From: Liz Hutchings
Sent: 28 May 2018 18:05
To: Anita Gardner
Subject: FG/64/18/DOC

FG/ 64/ 18 /DOC
E. A. Hutchings
42 Ferringham Lane, Ferring, BN12 5LU

Objection to discharge conditions

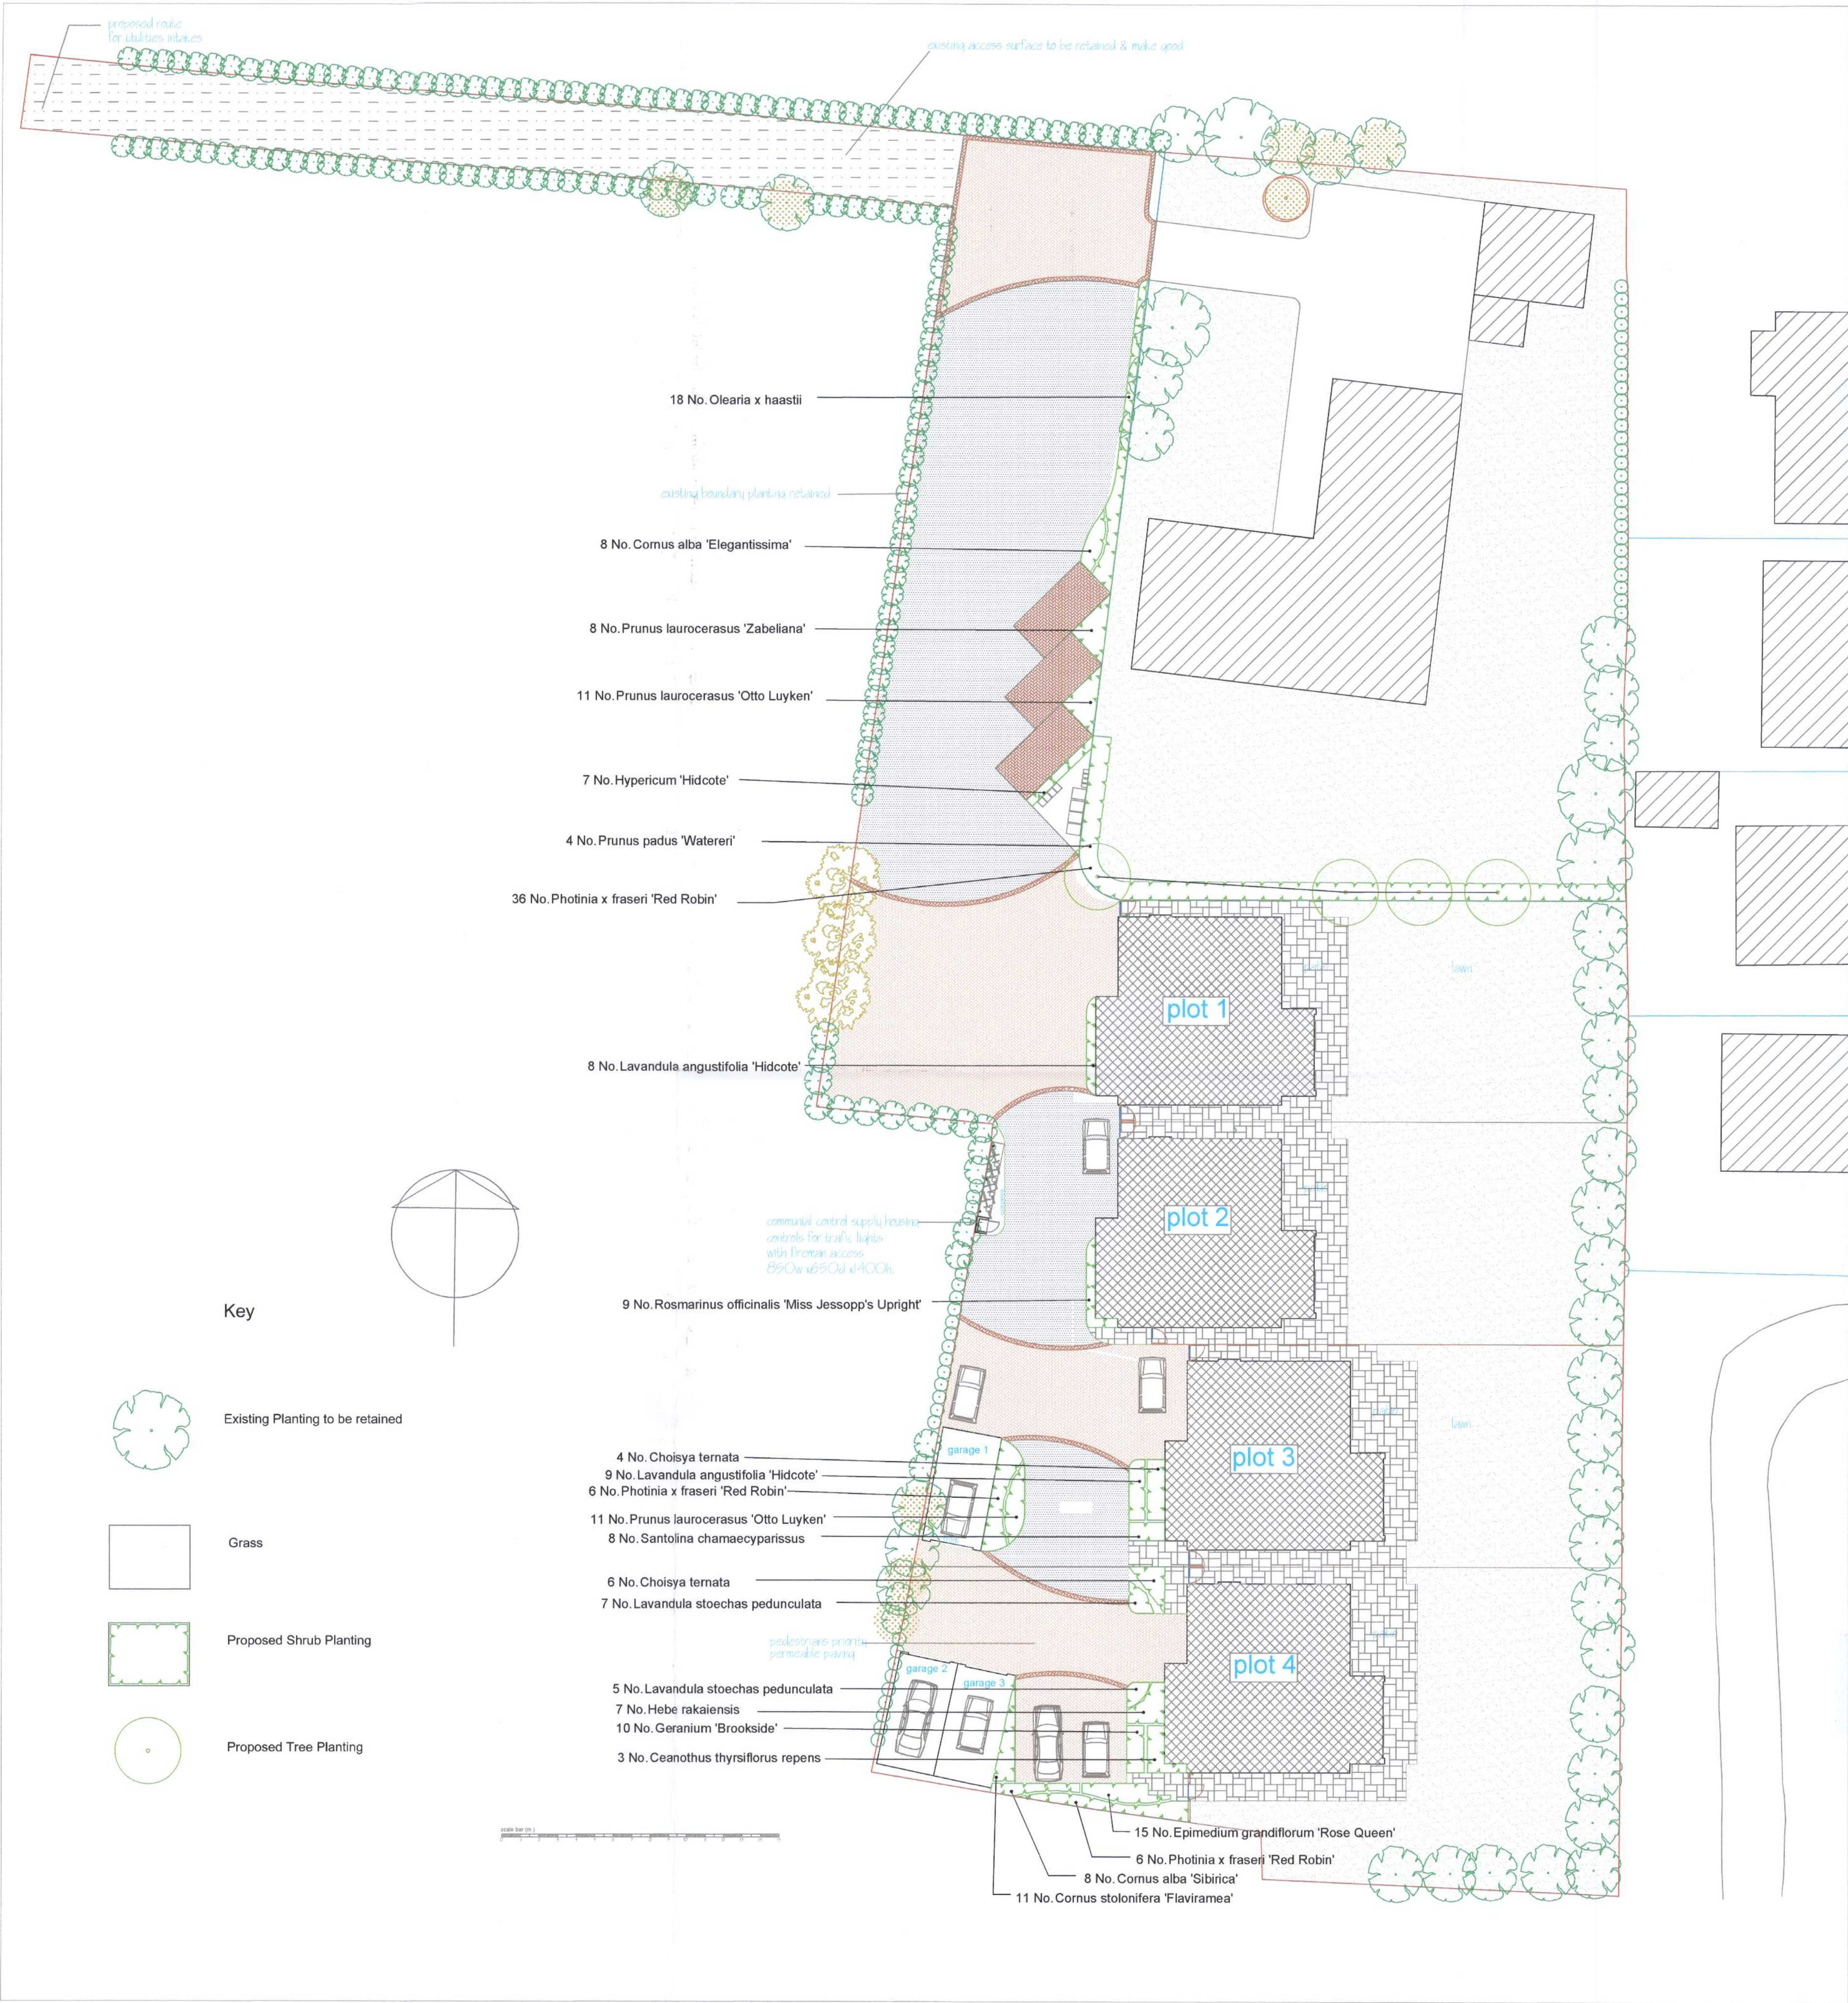
Planting proposed is minimal due to lack of space.

I would particularly note the area at the foot of my garden that has always been previously shown on plans as a green area to be retained where access road enters the plot and curves round to the right now looking like hard standing?

Only four medium trees on a site of this size is what one would expect of inner city housing estates.

These trees are positioned merely to offer some privacy to the existing house, as is much of the other planting.

It is not clear if the trees and shrubs will be within the garden of 44 or that of plot 1?

The landscaping plans do not show any planting to restore privacy to the surrounding neighbours' properties lost by prior removal of virtually every tree on the site, and now substituted with what appears to be two tone hardstanding from north to south bar small rear lawns of the new houses that border their boundaries.

SCALE 1:200 @ A1
DATE 14.05.2017
DRAWN sed
DWG No. 628-02 rev. G

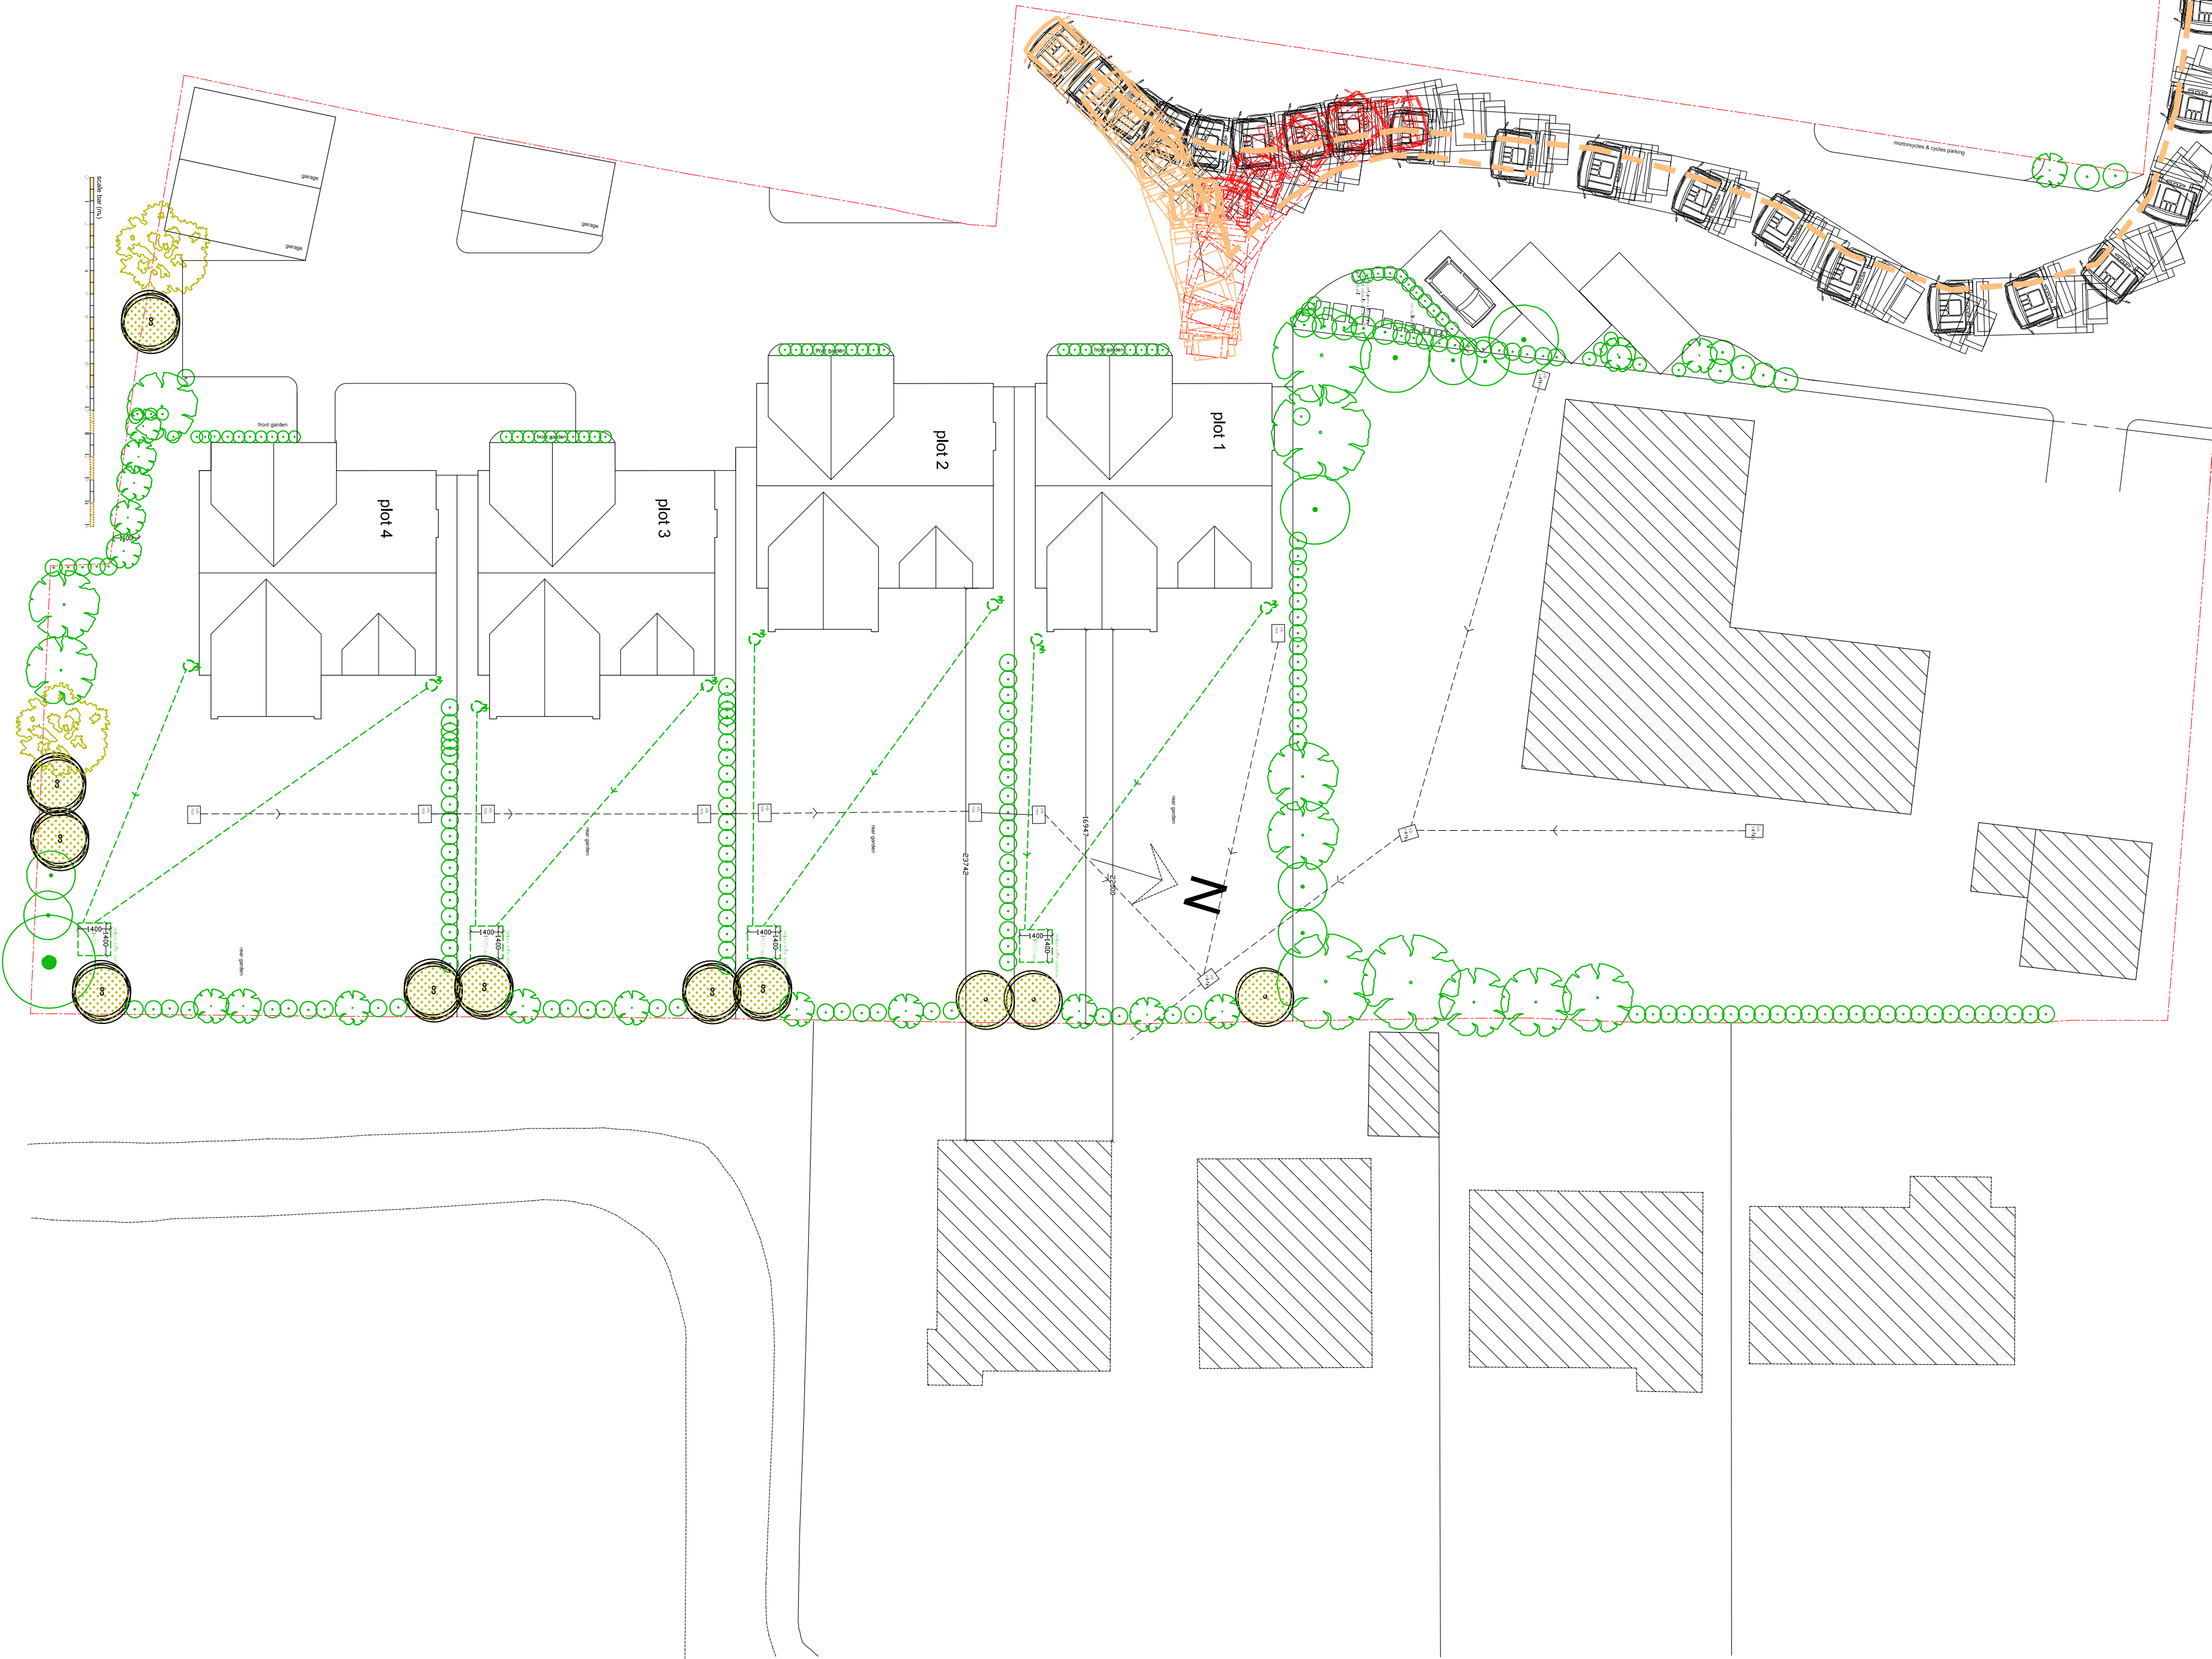
4. A plan to show vehicular waiting bays, queuing and route arrangements both at the road entrance and within the site as has been provided to illustrate the turning circle for lorries. *If a lorry is turning on site where will entering vehicles wait so as not to block the exit of said lorry?*

Plans now show an area of lawn eitherside of the new entrance into existing house reducing their parking space.

Does the client then have control over whether the current hardstanding for 5 vehicles remains as is to accommodate these, or will it indeed be laid to lawn as shown on the landscaping plan?
